**Lawful Development Certificate for a Proposed Use or Development**

**Development:** Lawful development certificate for a proposed garden/yoga room with decking area.  
**Location:** Thatched Cottage Arundel Road Norton PO18 0JX

SCALE 1:50

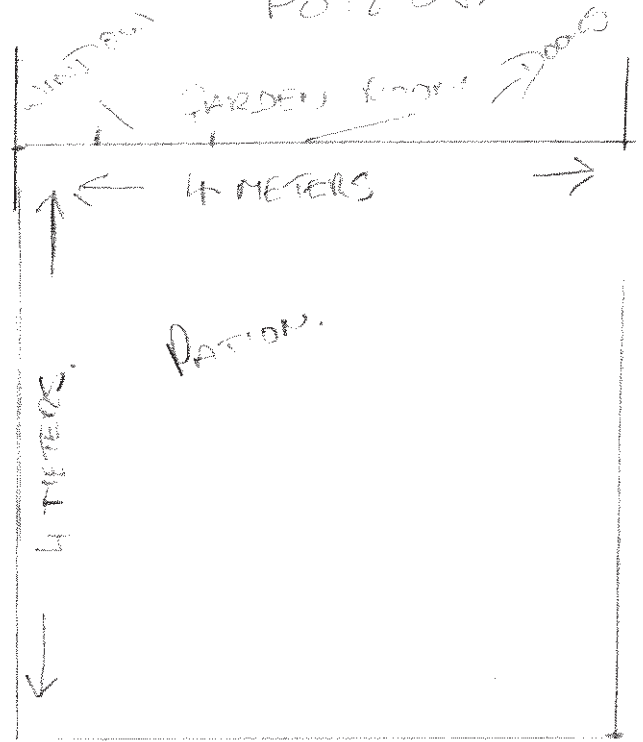
The submitted floor plan is not to scale. Please either re submit ensuring the scale is correct, or remove the scale bar.

BACK NORTHSIDE.

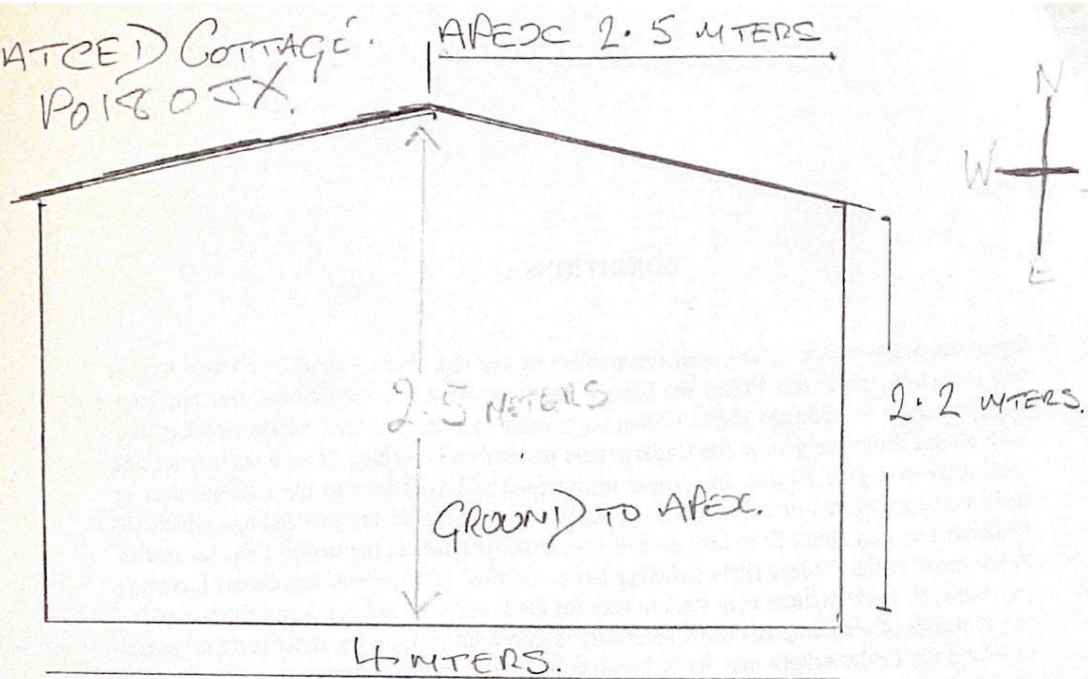
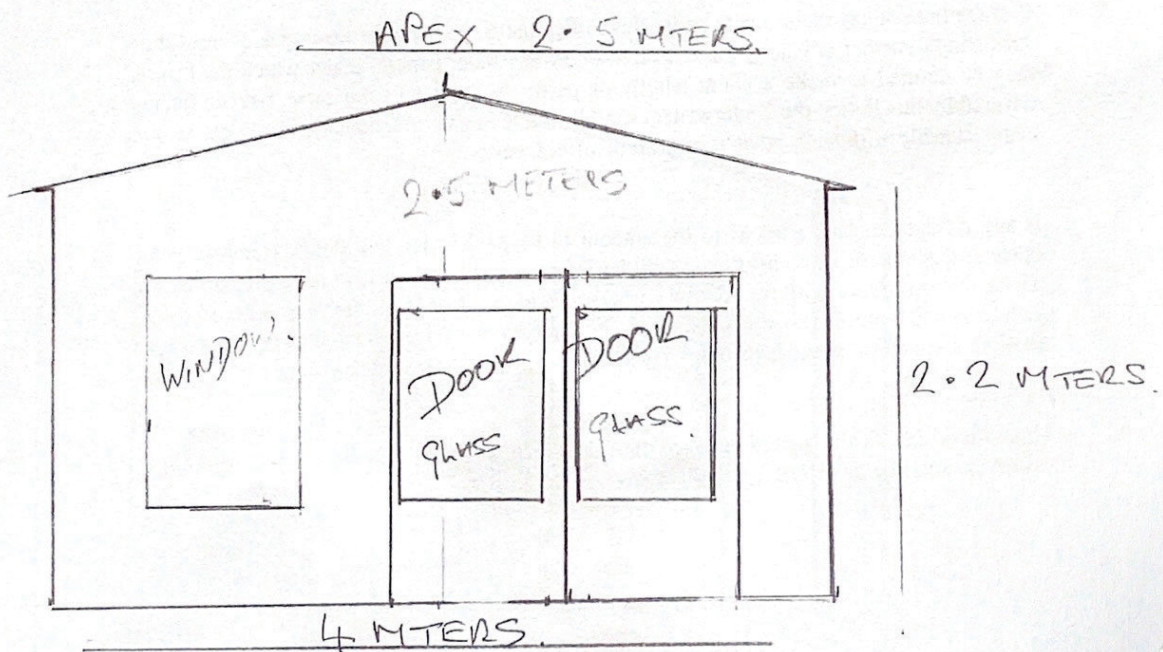
With reference to your email of 22nd February, the proposed elevations have not been received, only the floor plans. Please submit as a PDF.
